To: Director Of Services: Aircraft Noise Competent Authority, County Hall, Main Street, Swords, Co. Dublin.

I the undersigned make this submission in opposition to any change in the planning permission to allow night flights from Dublin Airport. Instead, we support the submission from the Saint Margaret's, The Ward Residents relating to this matter as summarized below:

Figure 13-3: 65 dB L_{den} Noise Contours, 2018 Baseline (blue), 2019 Baseline (red), 2022 Baseline (cyan), 2025 Baseline (yellow) and 2025 Consented (black)

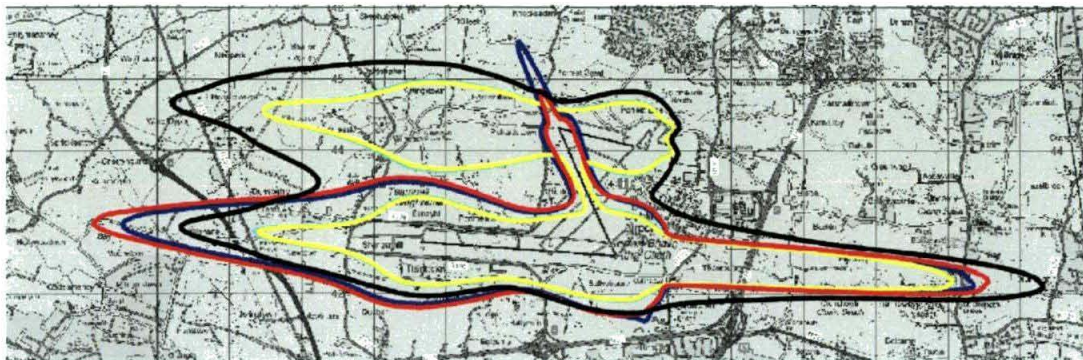
- ANCA and the DAA have totally ignored the objective of Target 2 of the EU Action Plan "Towards a zero pollution for air, water and soil" adopted in May 2021 as the targets for 2030 are set at far higher noise levels in 2019 and 2018, which far exceed the baseline year of 2017 required under the EU Action Plan. The selection of 2019 as the baseline is contrary to ANCA's own SEA document used to screen the project.

- The selection of 2019 or 2018 as the baseline for noise comparison does not meet the requirements of Directive 2002/49/EC as required by the Aircraft Noise (Dublin Airport) Regulation Act 2019. The escalating noise reported in noise action plans dating back to 2008 have been ignored with respect to reducing and prevention of noise at Dublin Airport.

- The figures presented by the DAA for 2018 as a baseline are incorrect as during 2018 the crosswind runway was used extensively and therefore the figures are distorted and are not accurate with respect to reviewing the current application. The health effects proposed to be inflicted on the St Margaret's The Ward community have not been evaluated by either the DAA or ANCA. The real cost due to health effects alone is calculated at more than €600 million per annum due to the proposal. **(Please Turn Over...)**
